Application: SSI 7485

I write regarding the proposed modification to M4-M5 Link, Mod 2 The Crescent overpass and changes to pedestrian infrastructure in North Annandale, Rozelle and Rozelle Bay Foreshore area.

Figure 4-2 Pedestrian and cyclist bridge infrastructure options

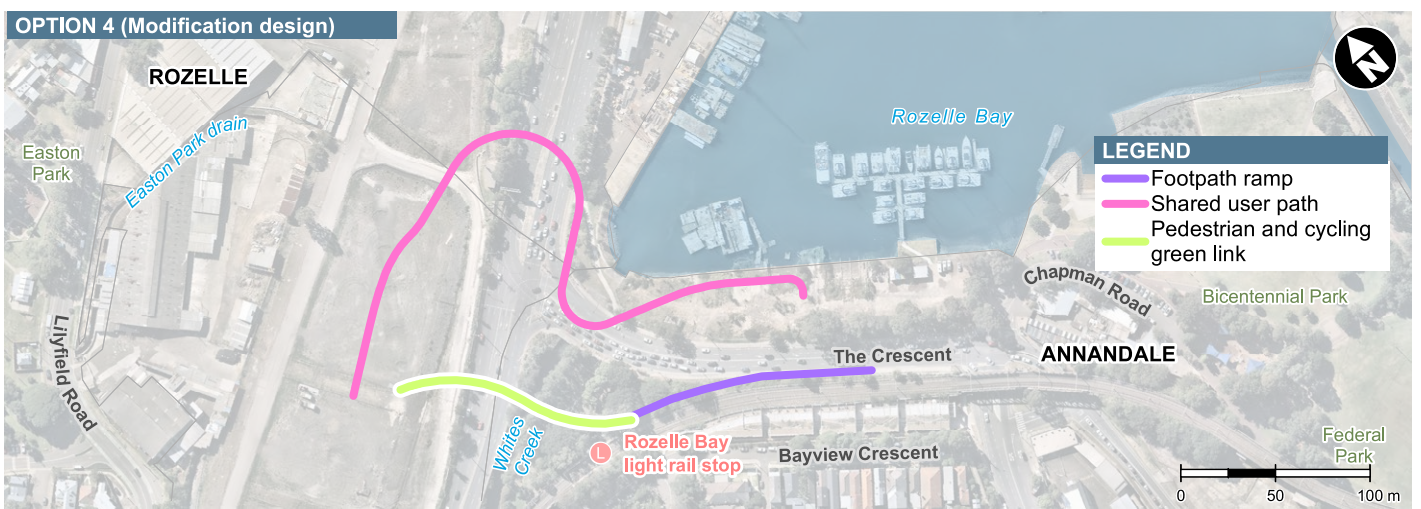
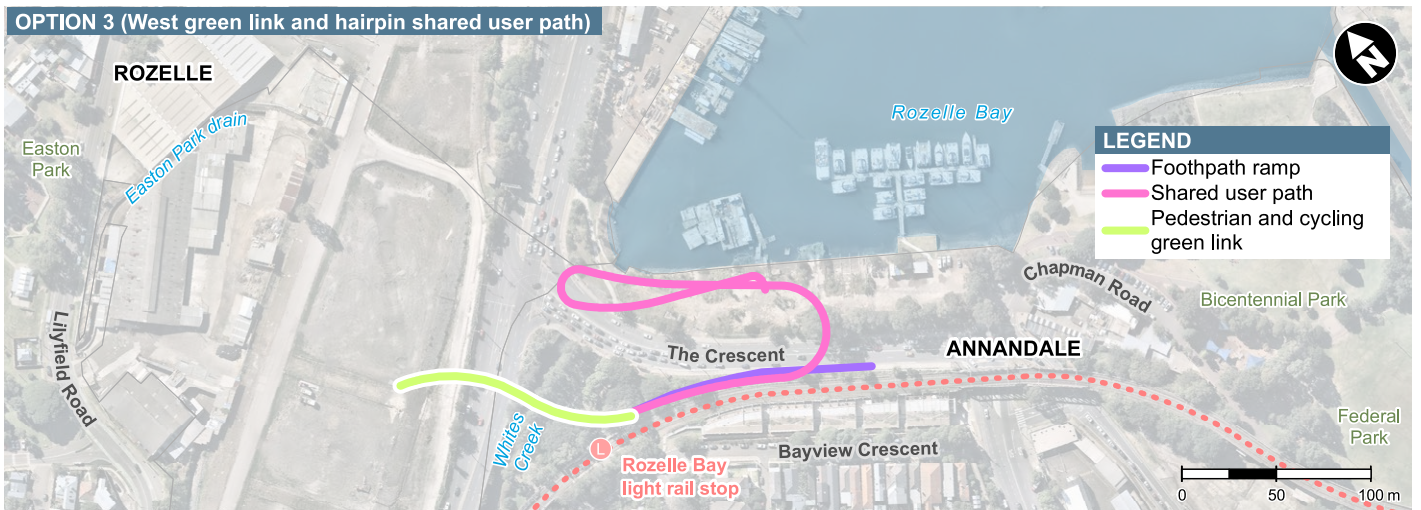
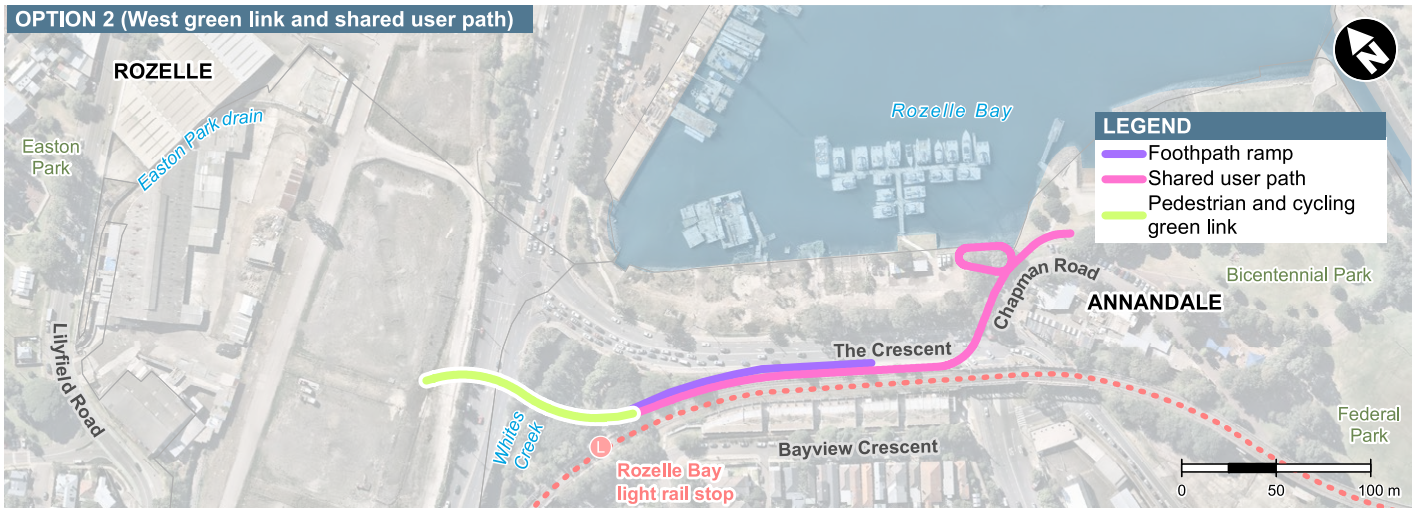
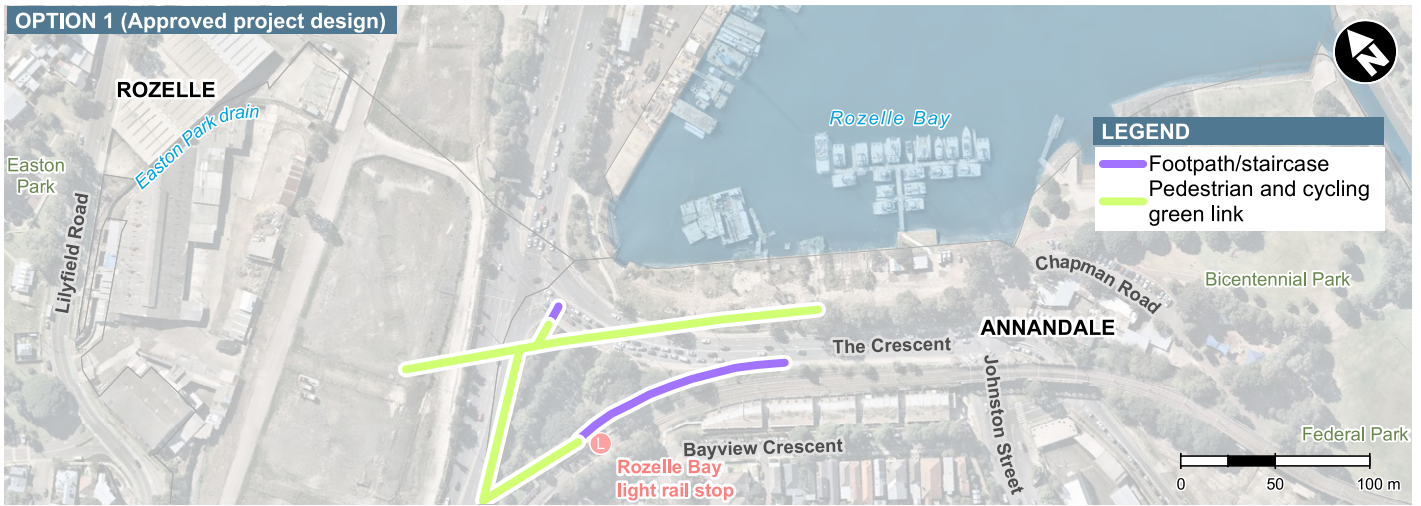
I request RMS work with the community to explore alternate design options to the proposed new car overpass design and the changed pedestrian and cyclist links. I am seeking the reinstatement of the safe, direct access from the approved EIS GreenLink to create a continuous green open space connection from the Rozelle Rail yards and Annandale to the foreshore. The GreenLink was more than just a walk way - it put people central to the design, maximising safety, and providing much needed accessible open space for the community now and into the future Bays Precinct design.

- The significantly reduced safety and increased risk for pedestrians and cyclists with removed access over The Crescent to Bicentennial Park and the increased traffic along Johnson Street.
- Being required to cross five sets of pedestrian lights at The Crescent as my option to reach the foreshore from Annandale or from Rozelle Bay light rail stop.
- Removal of direct active links to the foreshore, cutting the community off from the area and the proposed revitalisation of the entire Bays Precinct, including linking the Light Rail and Bus stops to a Ferry wharf and Metro station.
- Urban and landscape design that is being built before a finalised Masterplan for the area.
- Traffic changes that limit movements around the suburb and create further congestion in the local streets of Annandale, Forest Lodge, Glebe, Lilyfield and Rozelle with no planning to deal with these.

- Reinstall the GreenLink connecting communities and green open space from Rozelle to Bicentennial Park
- Relocate and design pedestrian and cyclist connections that are continuous, safe and direct.
- Design the modification infrastructure and active links in response to the character of the suburbs, the location of the foreshore and its potential future development.
- Provide pedestrian and cyclist paths that maximise people safety and do not force them onto busier streets, unsafe concrete plazas and caged walkways.
- Integrate active and direct connections to all active transport – including the future Metro West and Foreshore Ferry Wharf

Figure 4-4 Elevation: Indicative view of The Crescent overpass

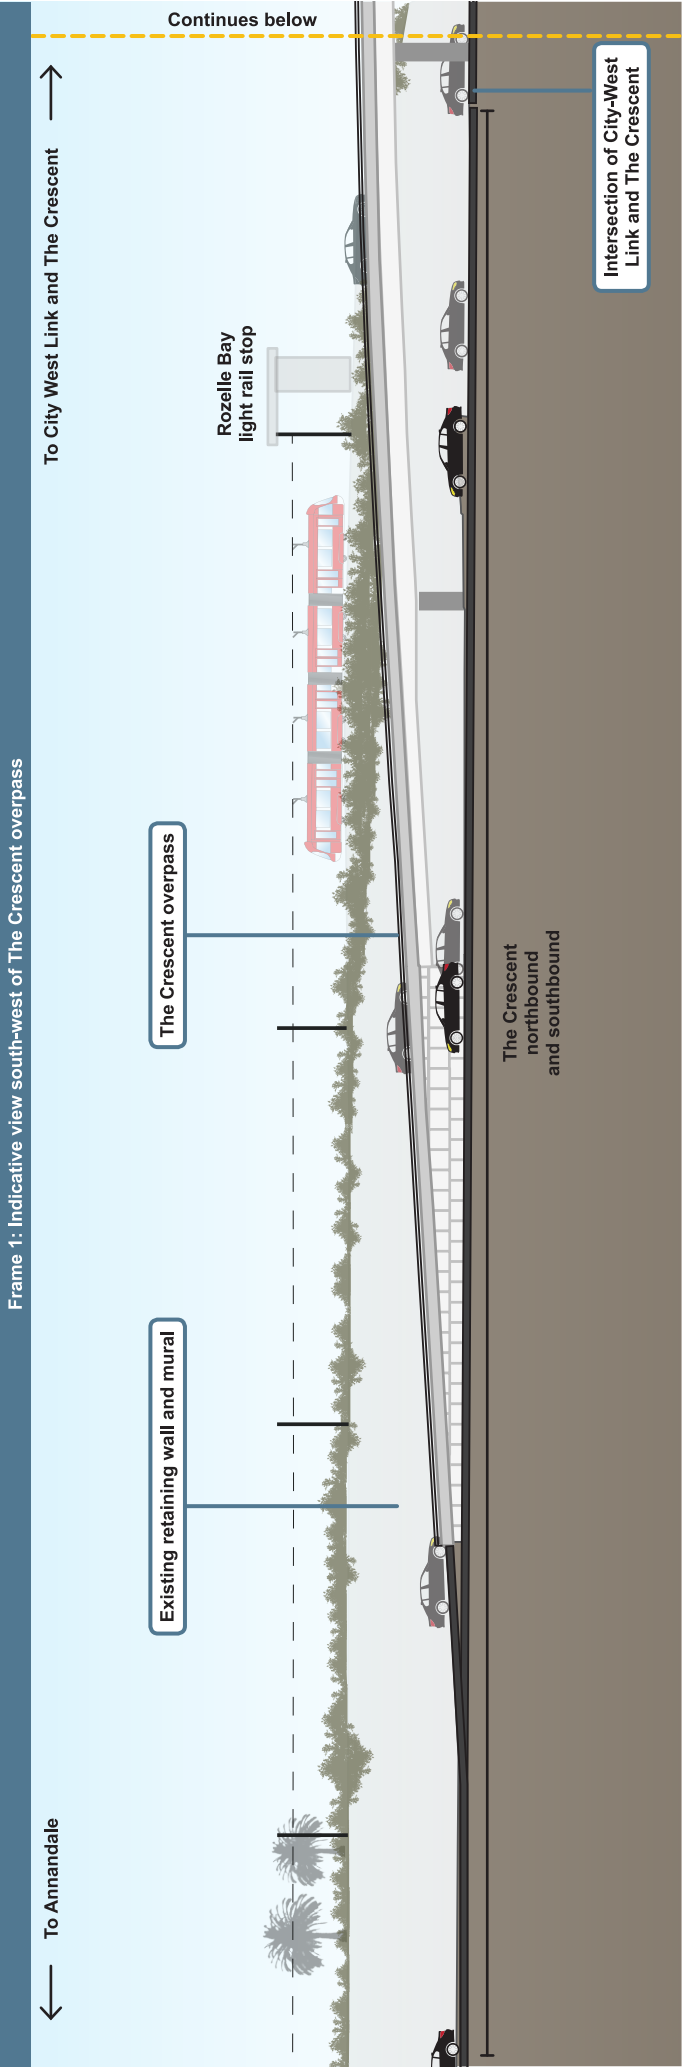
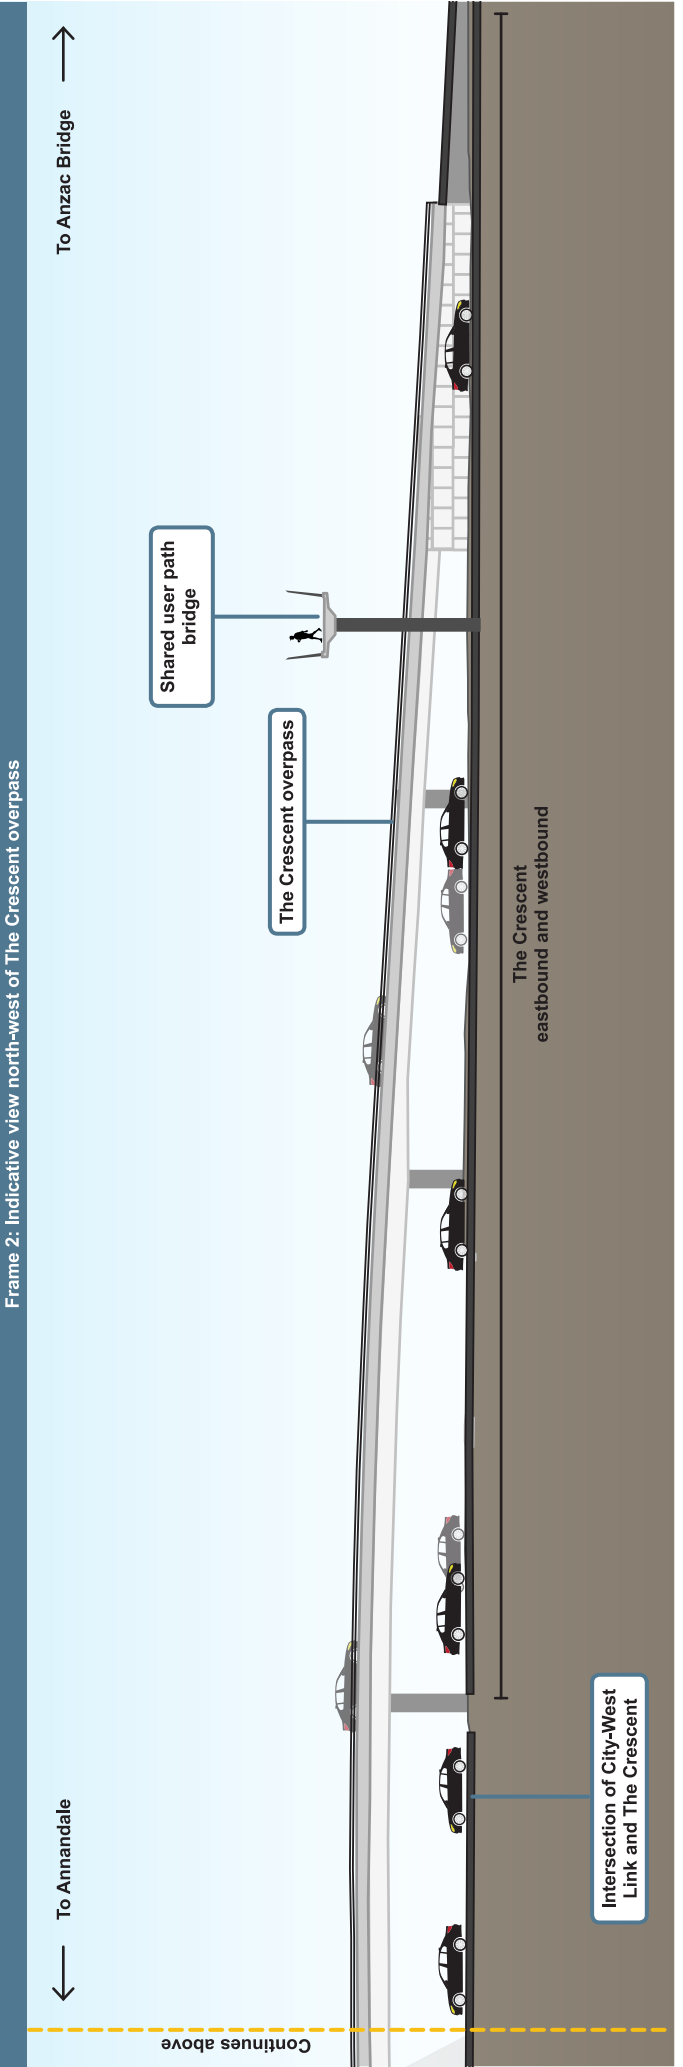
The recreation of ugly road bridges and overpasses in suburban settings. Sydney has enough ugly infrastructure (Cahill Expressway?!) built without thought for pedestrian, cyclist and non-vehicular use. The inner west is a vibrant community connected to its parkland - don't create ~~extra~~ concrete barriers between residential areas and the waterfront!
